**Consultation Response from KC,
Highways Development Management**

2024/90800 Prime Property Rentals, 115, Bradford Road, Fartown, Huddersfield, HD1 6DZ

Change of use from offices to takeaway and 2 additional dwellings, dormer windows to front and rear, new shop front, windows and associated works

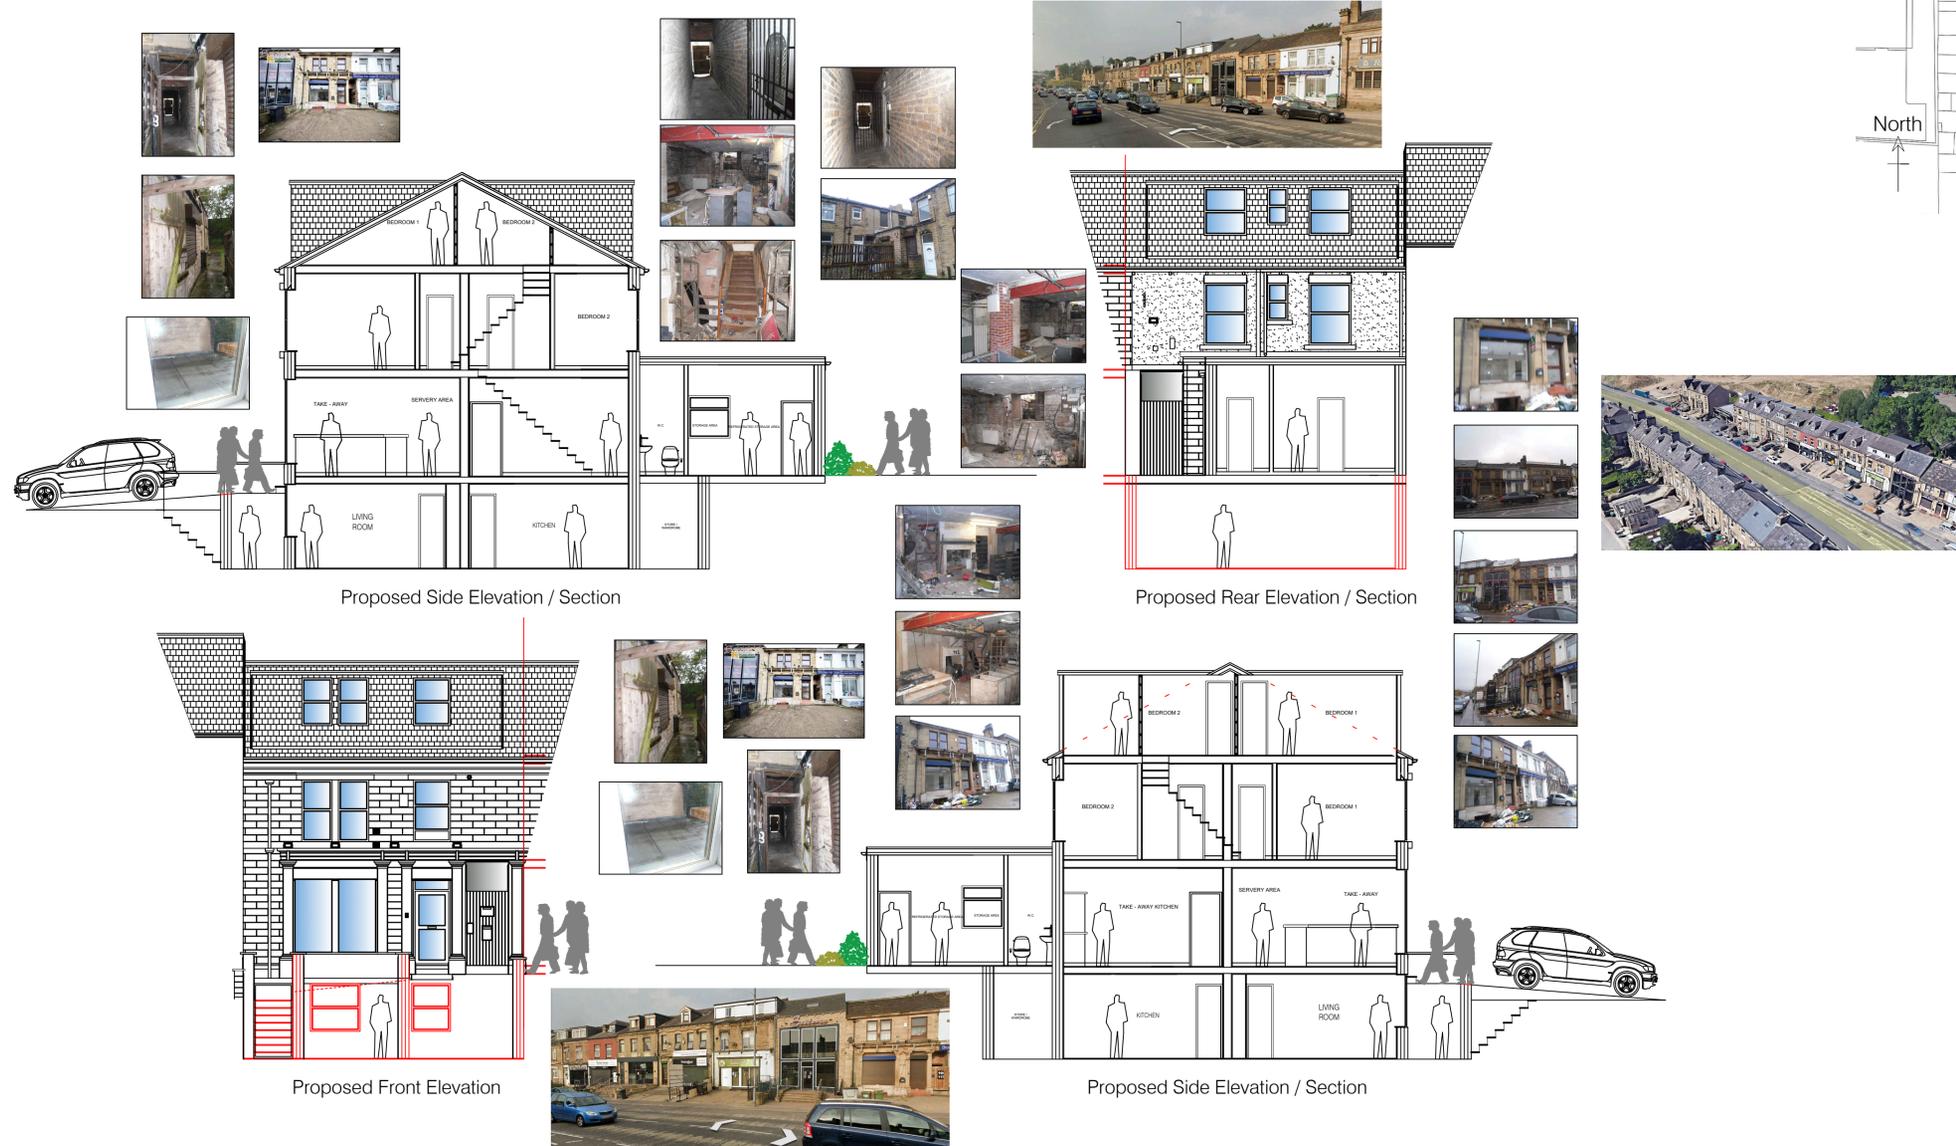
One off-street parking space is shown to the site frontage along with a flight of new steps which also contain the lightwell to the basement flat.

- 1, Highway Registry confirm that this section of Bradford Road is adopted to the back of the footway and that anything beyond this would be considered a private forecourt. Given that the light well is near the highway boundary the Highways Structures Section have requested that the applicants submit a fully detailed and dimensioned X-sectional drawing perpendicular to A652 Bradford Road to assess the impact of their proposals on the adjoining highway and whether a formal technical approval (via submission of an AIP) will be necessary.
- 2, The proposed parking space is accessed across the existing laybys along Bradford Road potentially between parked cars which can't be considered safe and should be omitted from the proposals.
- 3, The applicants should demonstrate that their proposals comply with the requirements of the waste strategy section comments attached.
